From: Tom [REDACTED]
Sent: 20 May 2021 08:38
To: Maria Tomalova <Maria.Tomalova@arun.gov.uk>
Subject: Re: Applications - AW/104/21/PL

PROPOSED NORTH (FRONT) ELEVATION

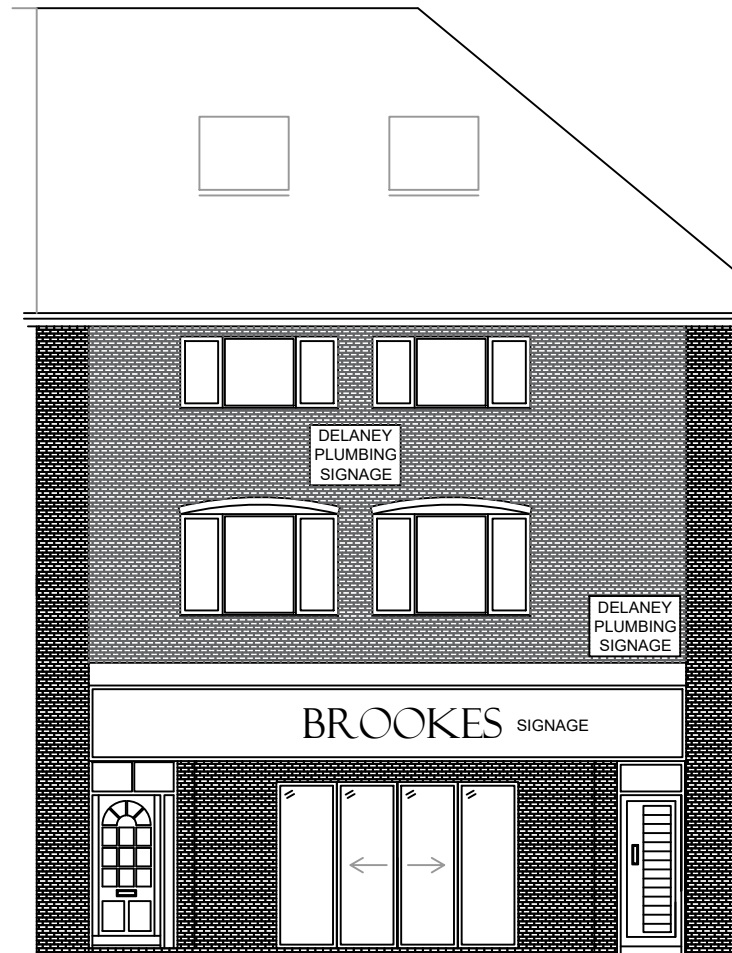
Having now discussed the various points with the client, I can confirm that they agree with some of the items including the balancing of the front elevation by providing matching doors to the office and dwelling. I know that ADC are not currently accepting minor alterations but might this be considered?

- 1) The double sliding doors have been chosen to provide easy access to the building for those with prams (family / parents with young children being the target audience). A dedicated area for the storage of prams is to be provided under the stairs.
- 2) Automatic doors will also provide easier access for wheelchair users and the ambulant disabled. The owners wish to make the facility as inclusive as possible.
- 3) The sliding doors are more space efficient and could be operated individually or as a pair.
- 4) The large area of glazing is intended to provide a visual connection to the street.

Drawing No.	Date:
D.1091 - 06	04-03-21
Rev.	Date:
A	27-03-21

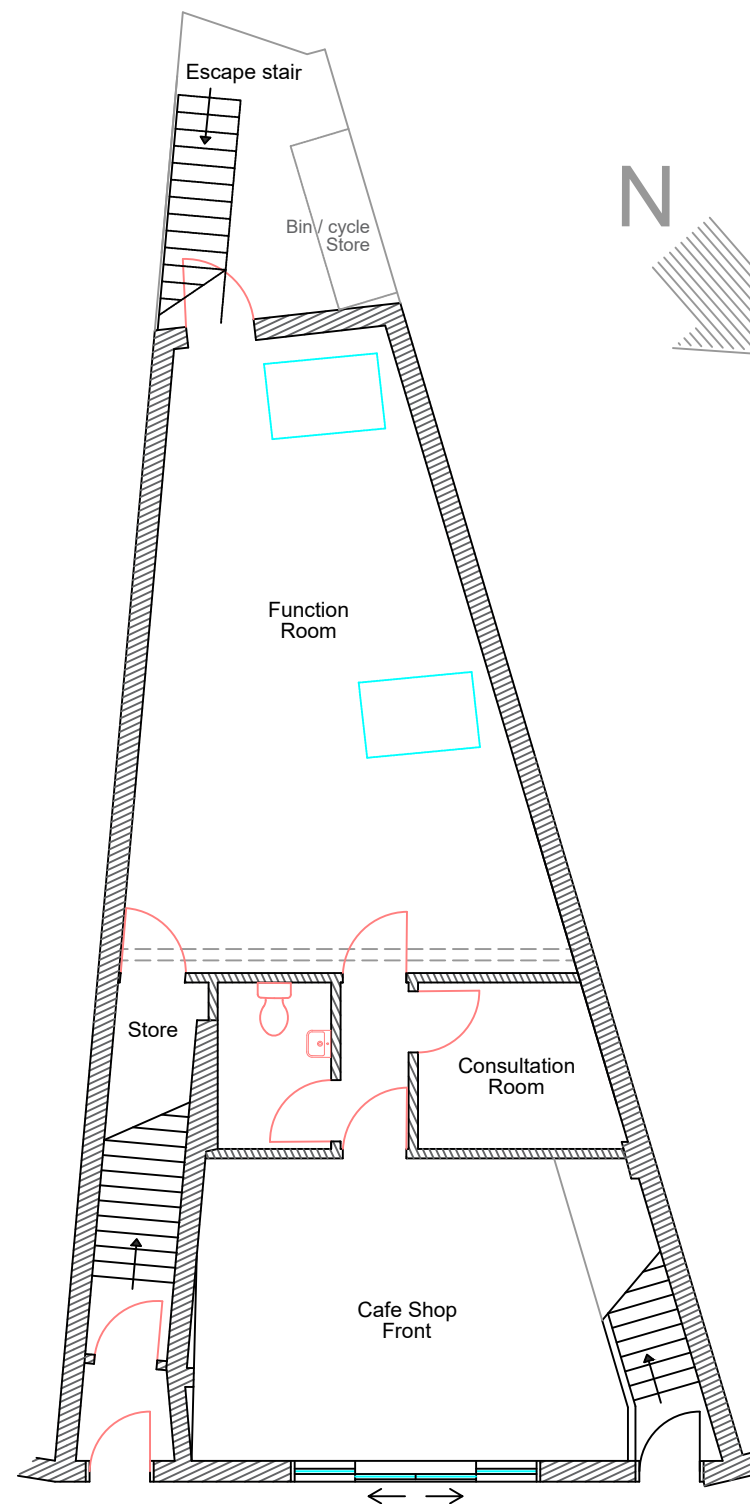
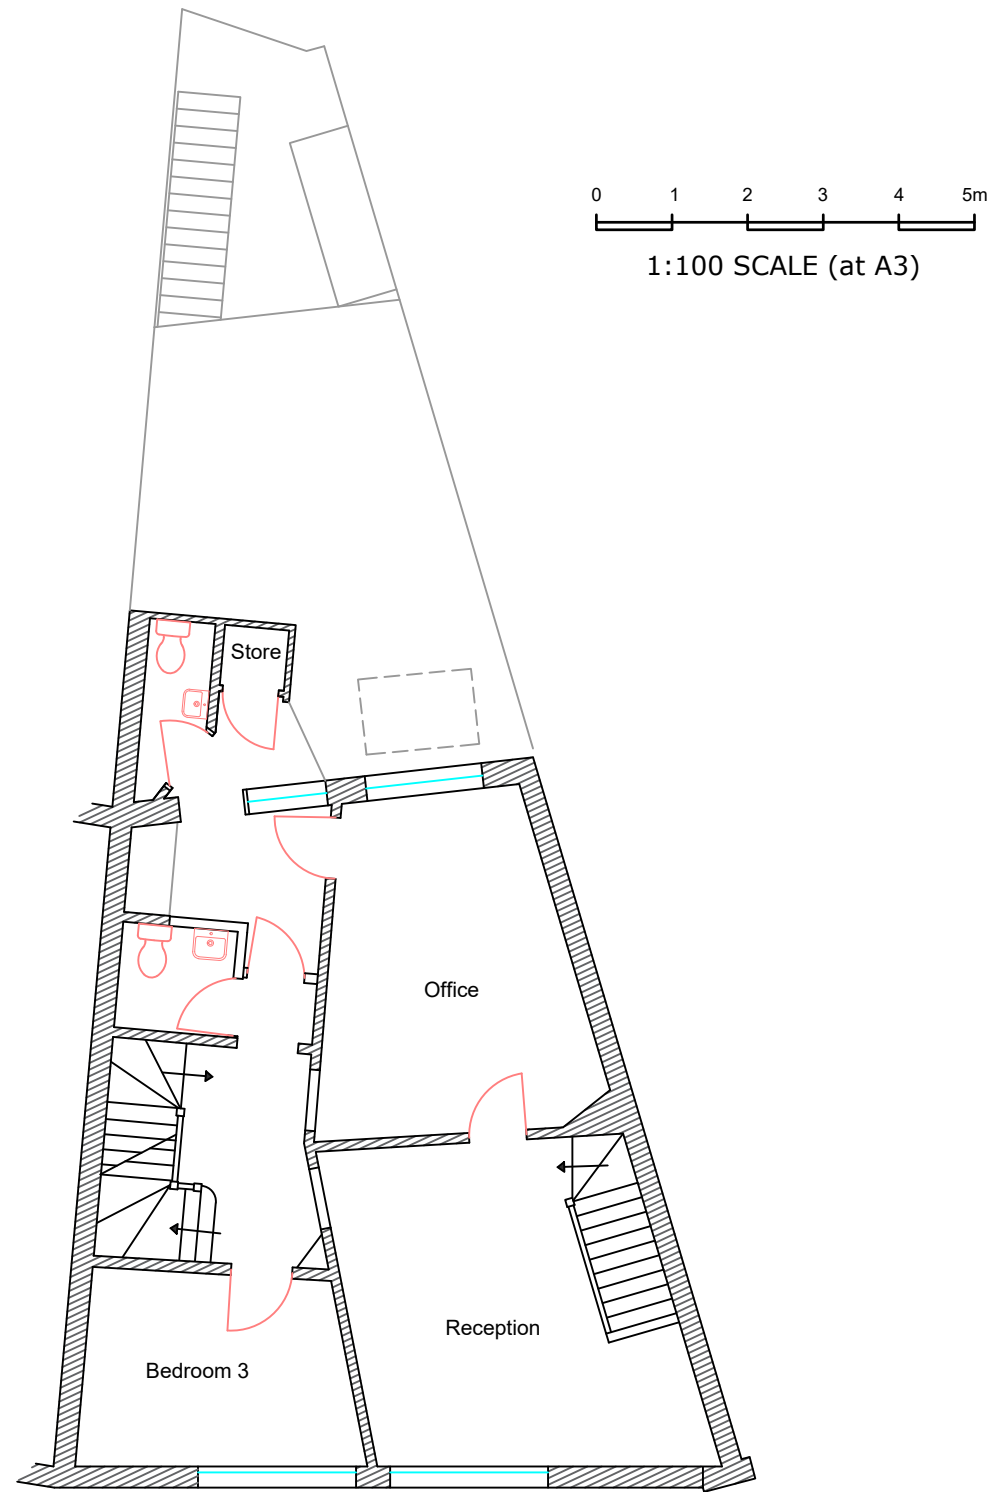
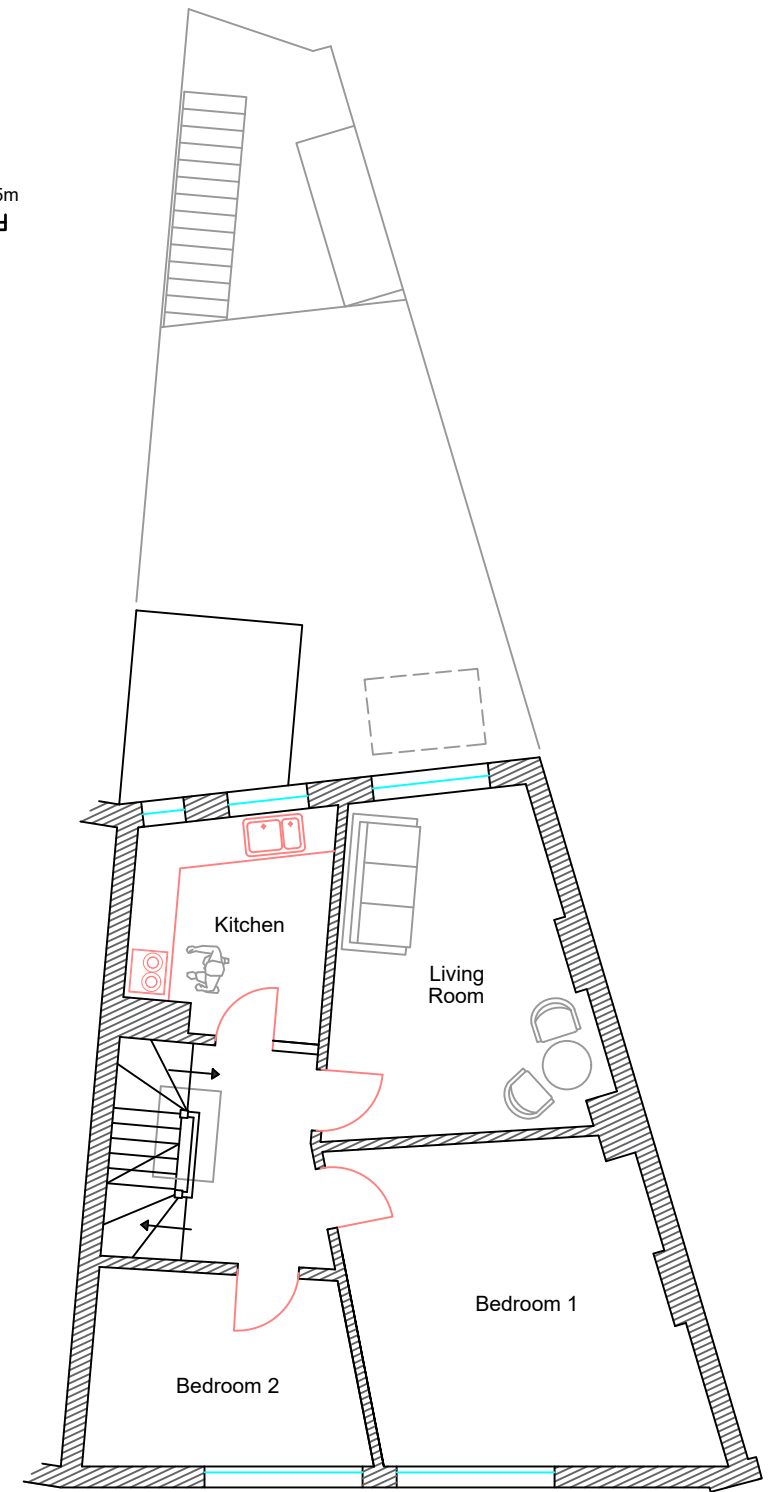
You can't use a flat roofed area as a balcony due to a vicinity of residential to the east. Overlooking, violation of the privacy.

- 1) The bedroom on the first floor should read as a study (I had resent this information to the admin team already) (drawing attached for reference)
- 2) The space on the first floor balcony, roof area and rear courtyard will be made available to the dwelling
- 3) The rear of the extension measures 3.25m at its narrowest and 6.6m at its widest point (abutting the main building).
